### **OUR CLIENTS: MR RICHARD GILL, MRS LISA GILL & DRONE DEFENCE SERVICES LTD SUBMISSIONS FOR DEADLINE 5**

2. Caunton Lodge Farm Landscape Technical Note including Residential Visual Amenity Assessment (April 2026)

# Cauntton Lodge Farm, Norwell Woodhouse.

Landscape Technical Note including Residential Visual Amenity  
Assessment (RVAA)

Viewpoint 32  
Norwell Woodhouse

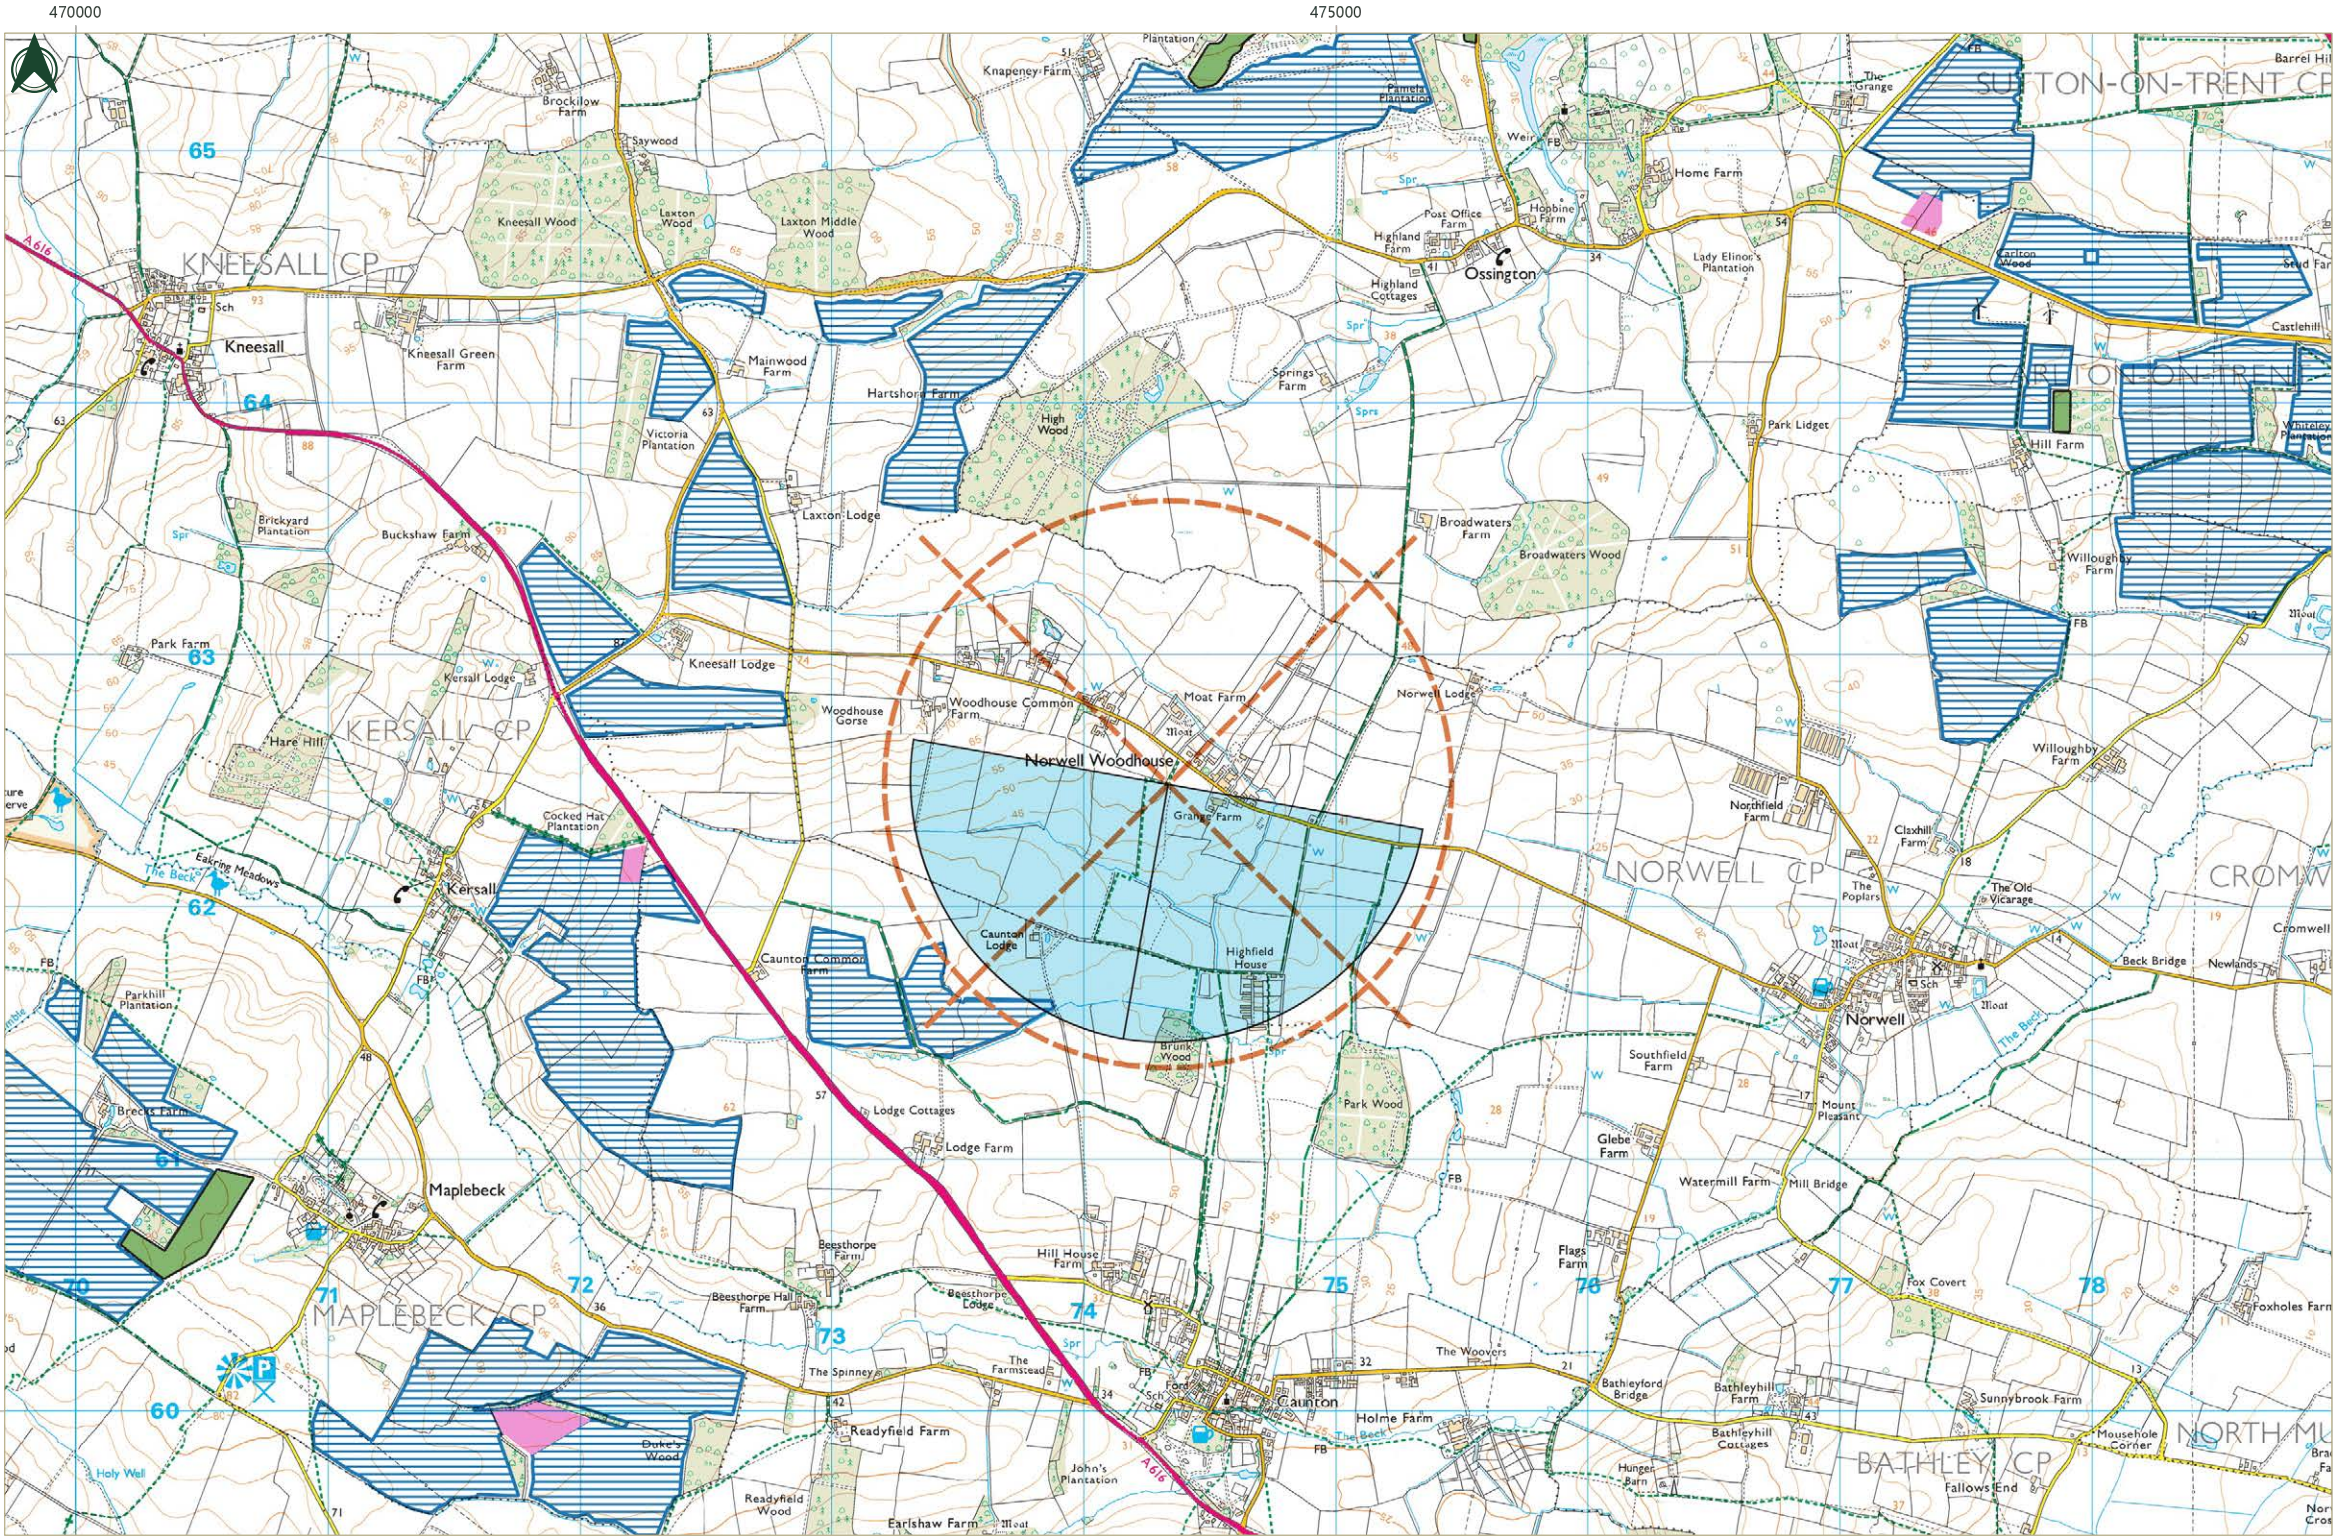
views travelling from Norwell Woodhouse are illustrated in Viewpoints VP12 and VP13 and are representative of the location where the house, its gardens and the proposed development features might be seen in a single view on arriving at the property. Arriving from the south the open agricultural fields, adjoining the track, are an important element in the setting of the property. The southern access track and its relationship with the property is clearly identified in the photograph below, taken from the dwelling.
